# Rezoning Transportation Analysis

Petition Number: #2022-157

Date	Description
02-22-23	First Review (TM)
04-20-23	Second Review (ME)
06-21-23	Third Review (DR)
07-25-23	Fourth Review (DR)

RZ-1

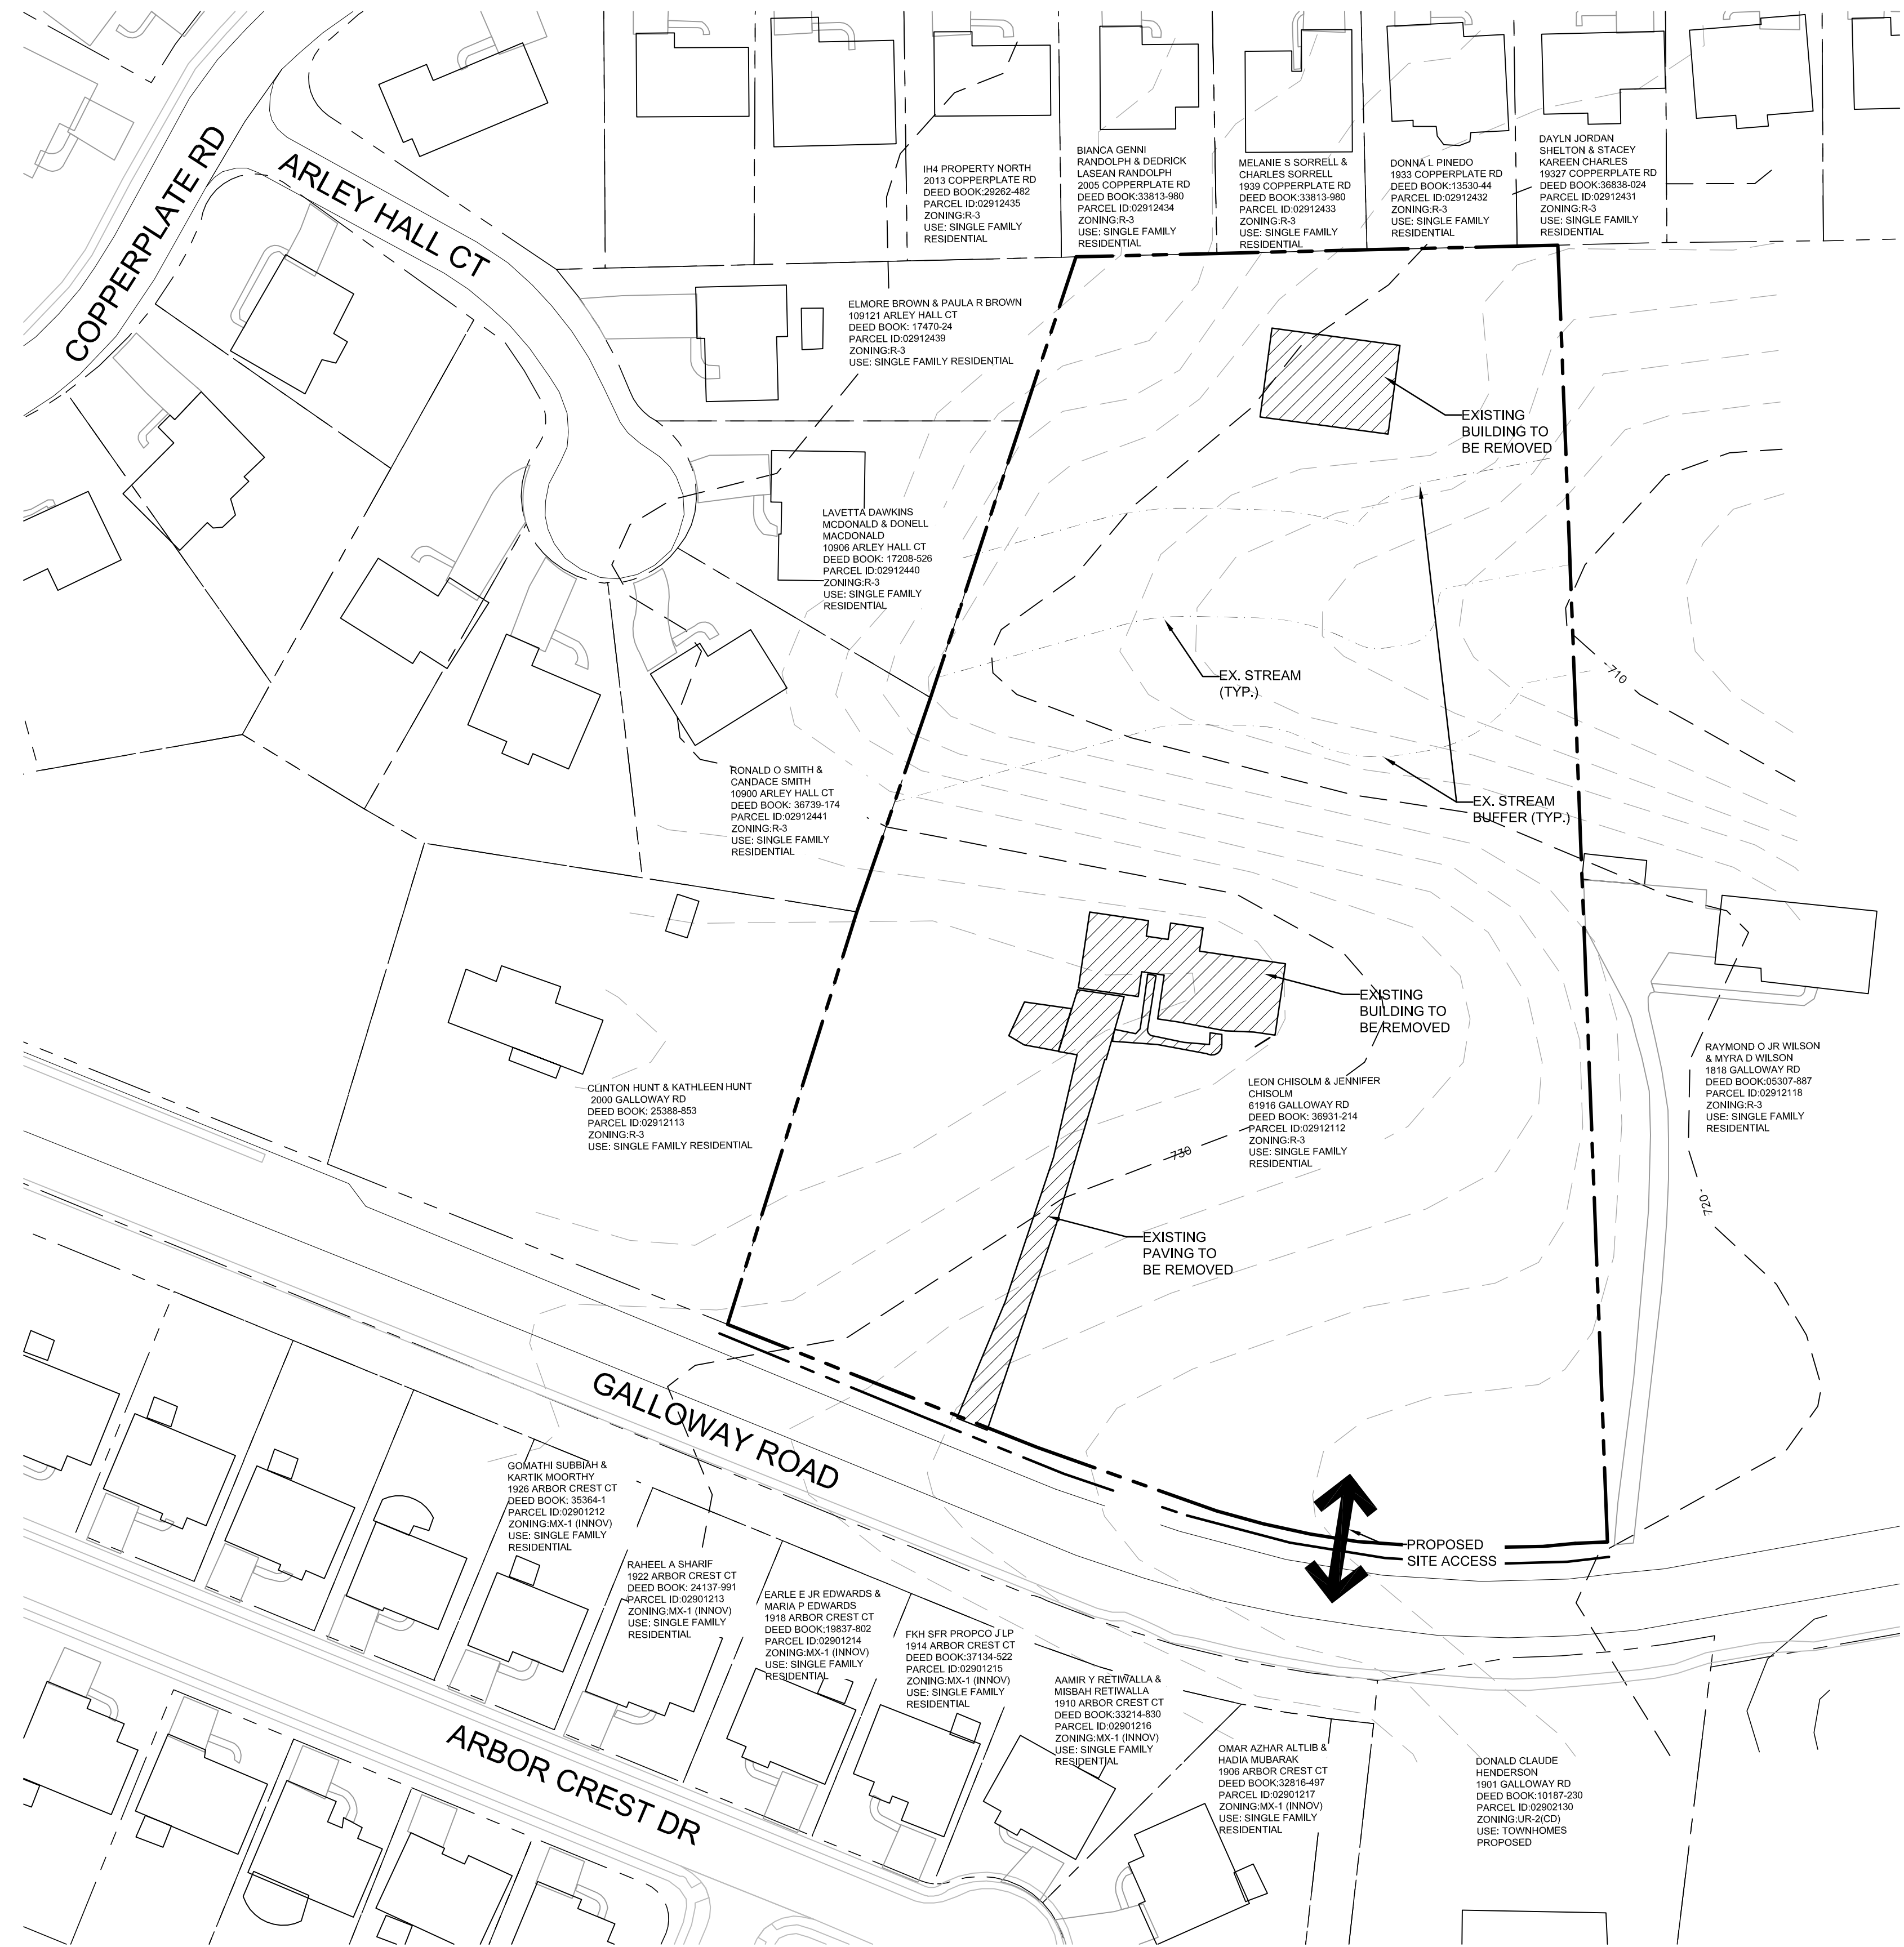
- a. ~~**Galloway Road:** Location of curb and gutter to be moved to 17.5 feet from roadway centerline to accommodate the Charlotte Streets Map with a roadway typical per CLDSM U-07.~~

~~Label and dimension the curb and gutter from the centerline for each road on the site plan.~~

3. ~~Revise site plan and conditional note(s) to commit to dedicate 36 ft right-of-way from the road centerline. The site plan shall label and dimension the right of way from the road centerline.~~

4. ~~**Outstanding Comment From 02-22-23:** Revise site plan and conditional note(s) to commit to providing 75 feet of internal protected stem. Dimensioned from curb return to curb return.~~

**Clarifying Comment 04-20-23:** Revise site plan by dimensioned from curb return to curb return.

- ~~6. CDOT REQUEST that site plan revisions and conditional note revisions are made to commit to constructing the internal private roadways and alleys to CLDSM standards 11.13 and 11.19 respectively. Site plan shall callout standards on site plan and noted in a conditional note.~~
7. Revise site plan and conditional note(s) to commit to extending private street stubs to the property line.
